RE: ENGINEER CERTIFICATION FOR DOUG ZIMMERMAN OFFICE WAREHOUSE  
(D-18/D28) CERTIFICATION STATEMENT DATED 12/23/93

RE: REVISED DRAINAGE PLAN FOR DOUG ZIMMERMAN OFFICE WAREHOUSE  
(D18-D28) REVISION DATED 7/16/93.

RE: REVISED DRAINAGE PLAN FOR DOUG ZIMMERMAN OFFICE WAREHOUSE (D18-D<sup>28</sup>)  
ENGINEER'S STAMP DATED 7/2/93.

DRAINAGE PLAN FOR
B ELECTRIC
SAN FRANCISCO AVENUE N.E.
ALBUQUERQUE N.M.

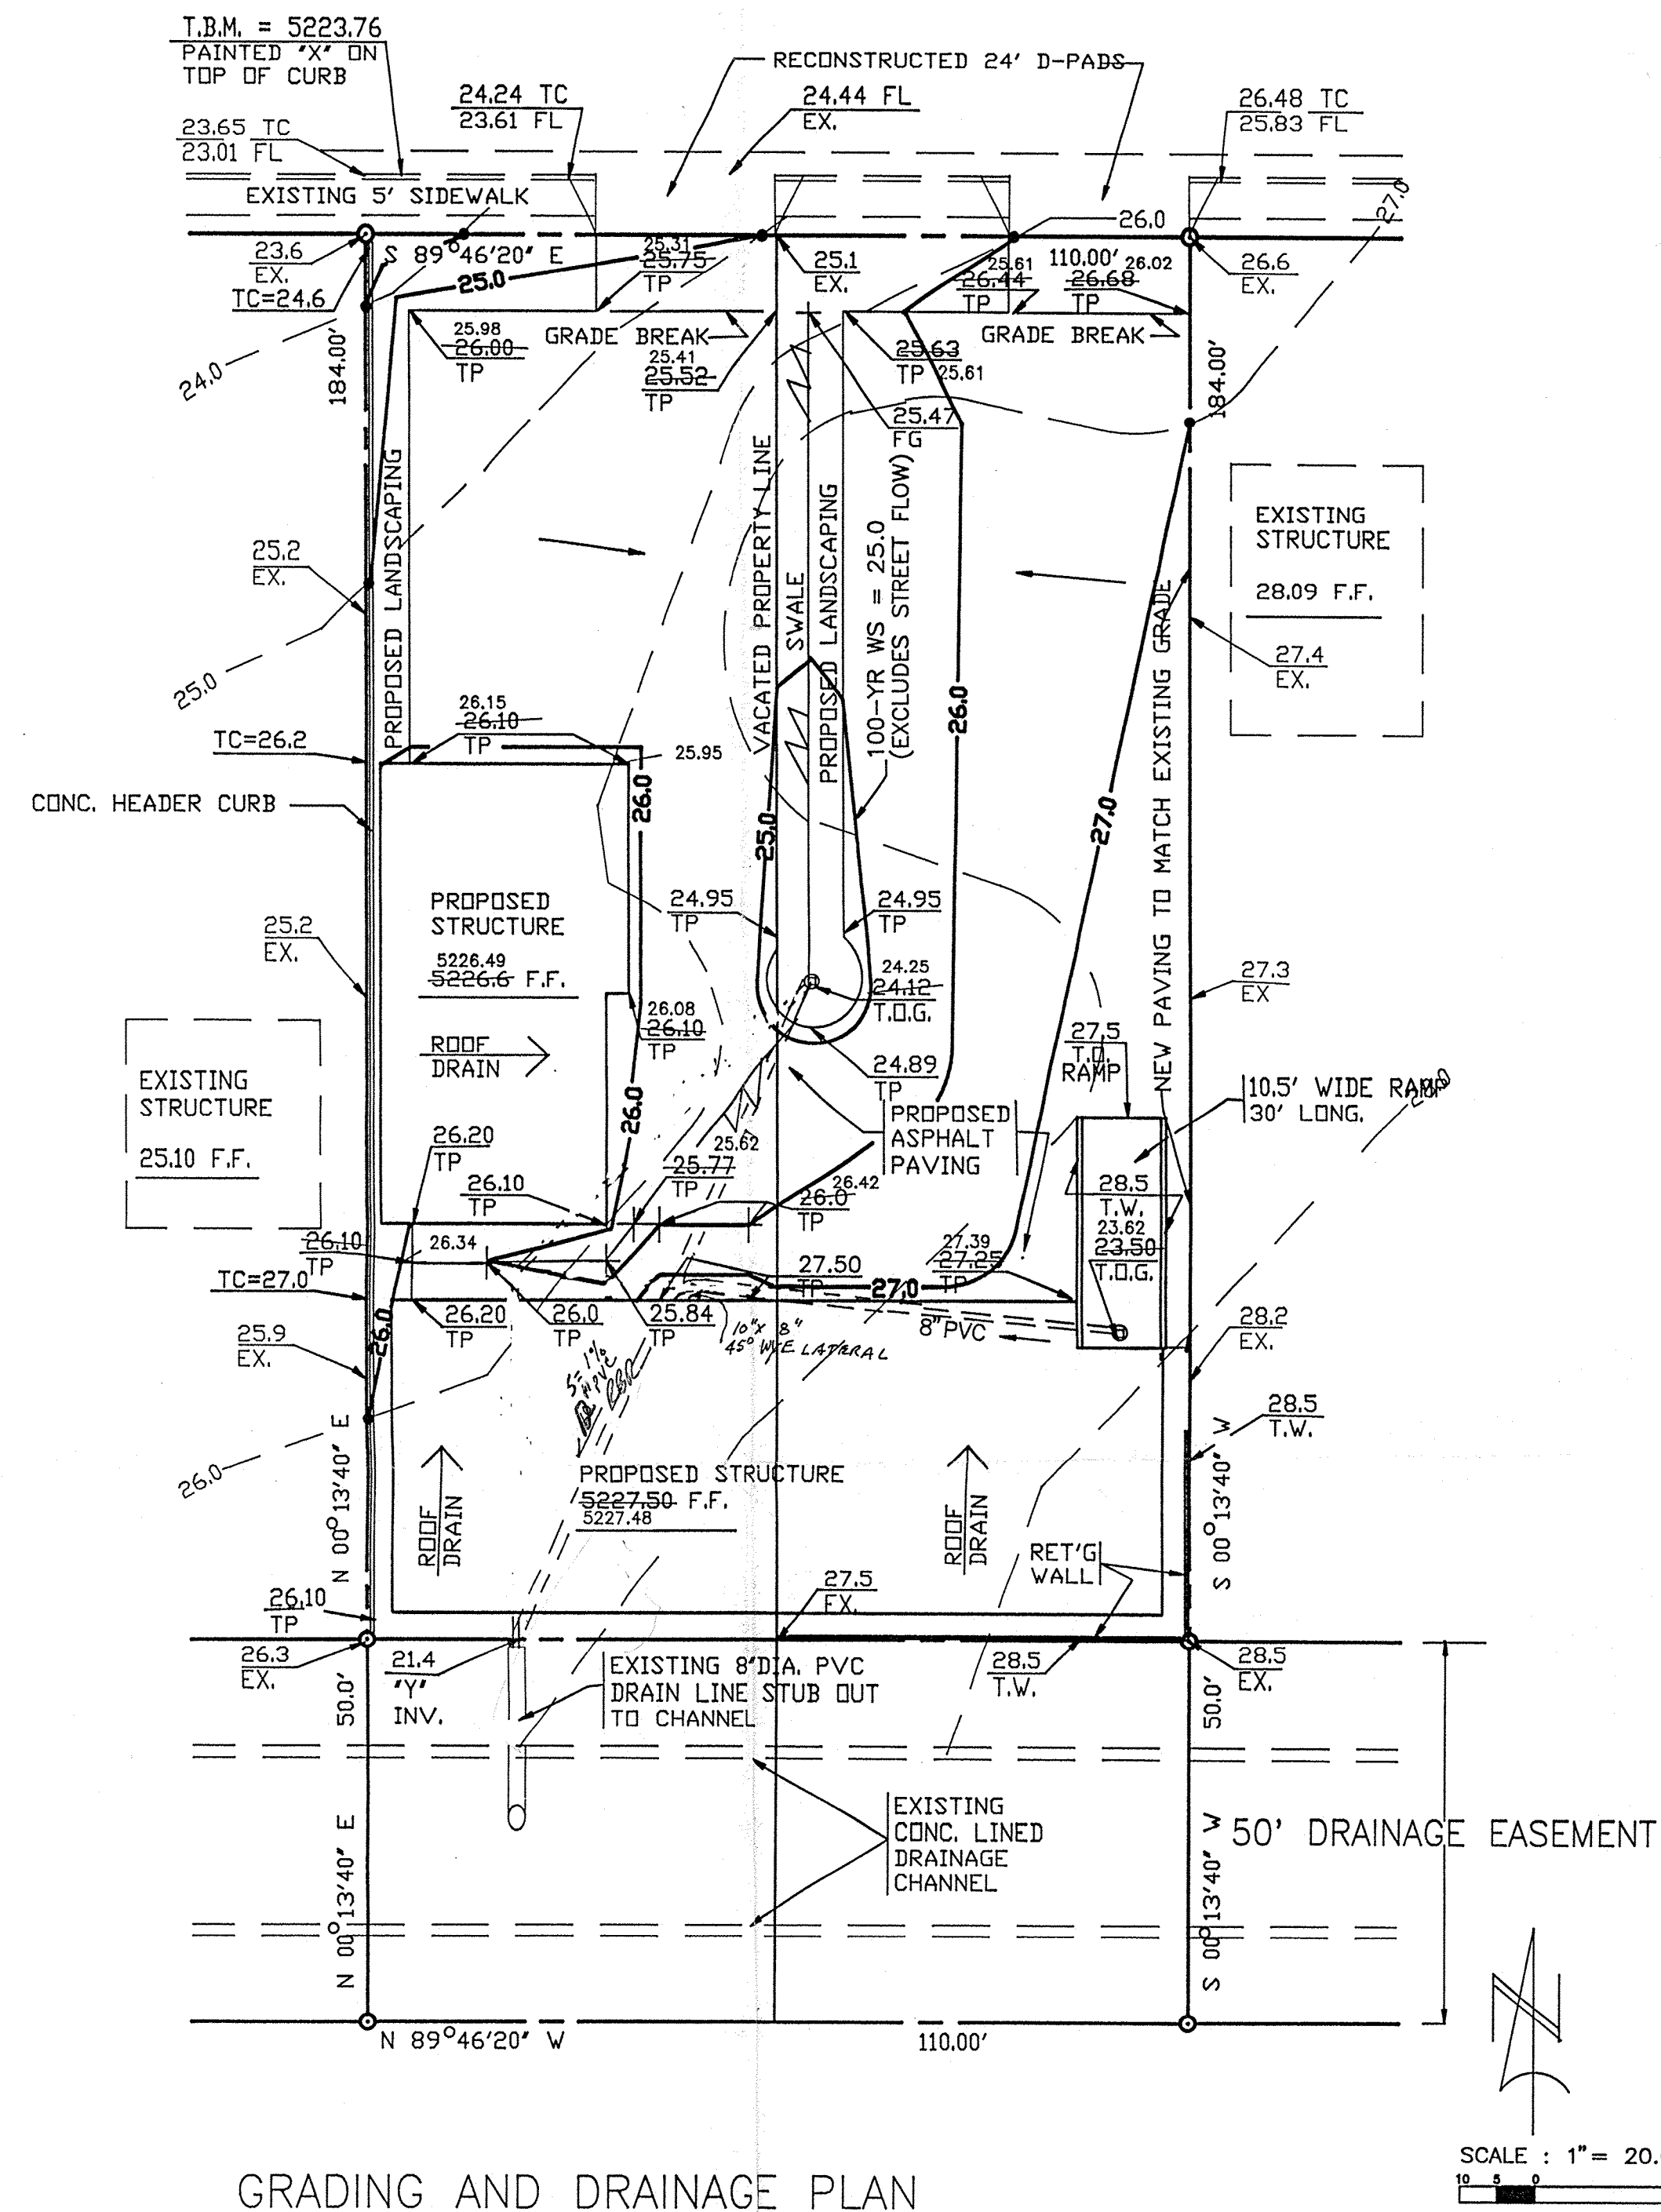
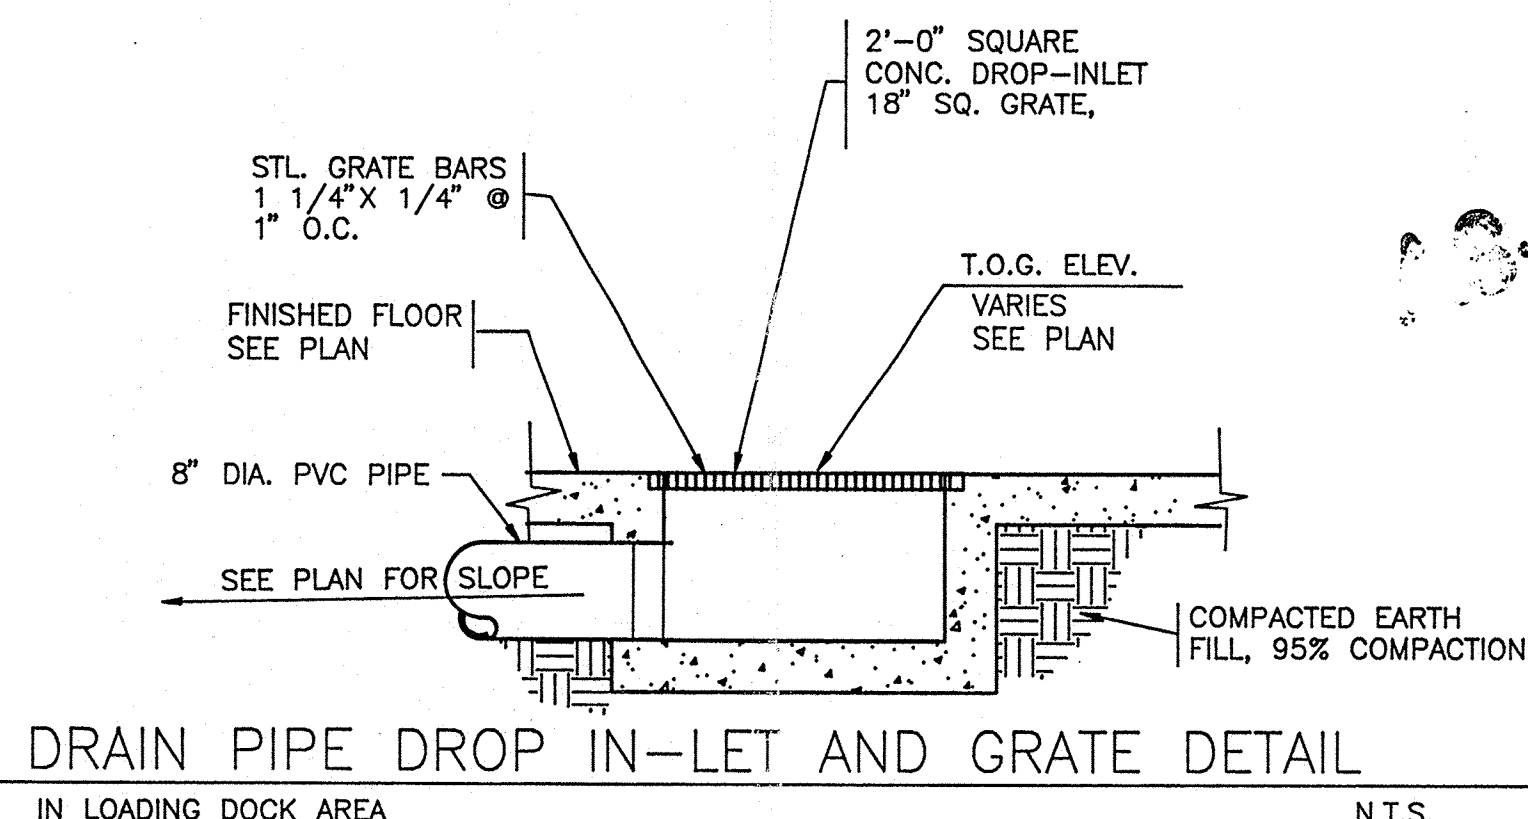
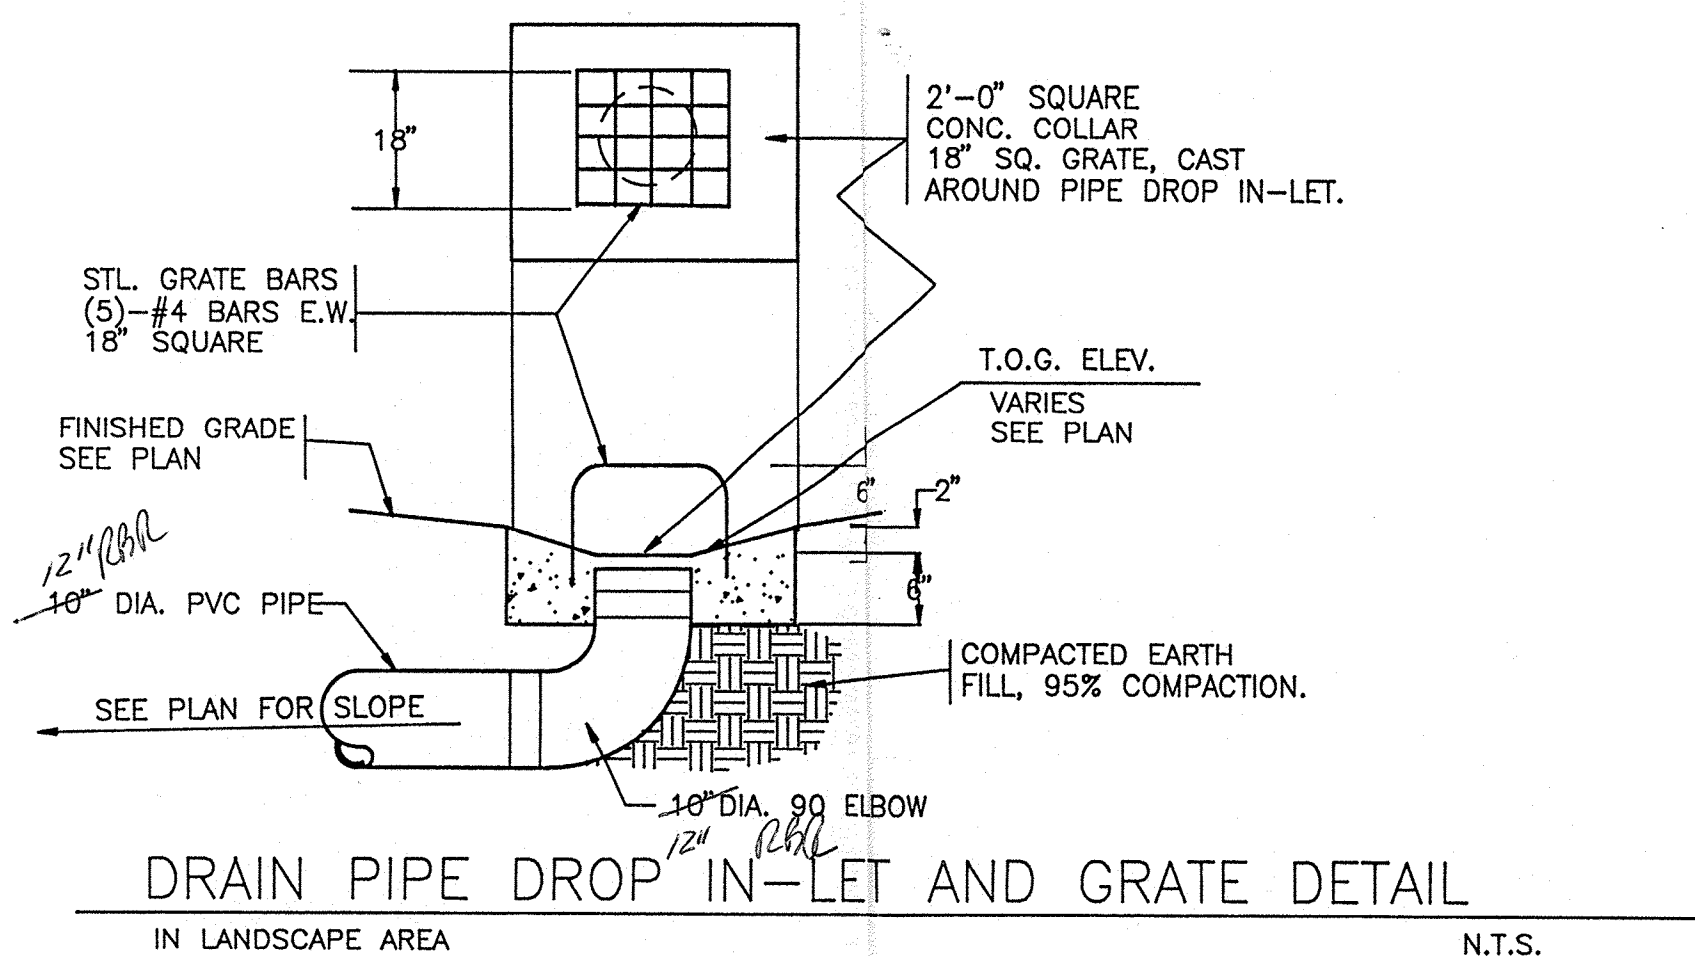
1. Copy of signed and recorded replat.
2. Hydraulics for the original concept where done using 1.12 cfs as the total flowrate. You must analyze the Hydraulics using a new total of 3.13 cfs. Show hydraulics for the inlet and pipes.
3. You may need to design for storage of the excess flows that the inlet and pipes will not be able to carry. Use the D.P.M. checklist as a guide for ponding requirements.
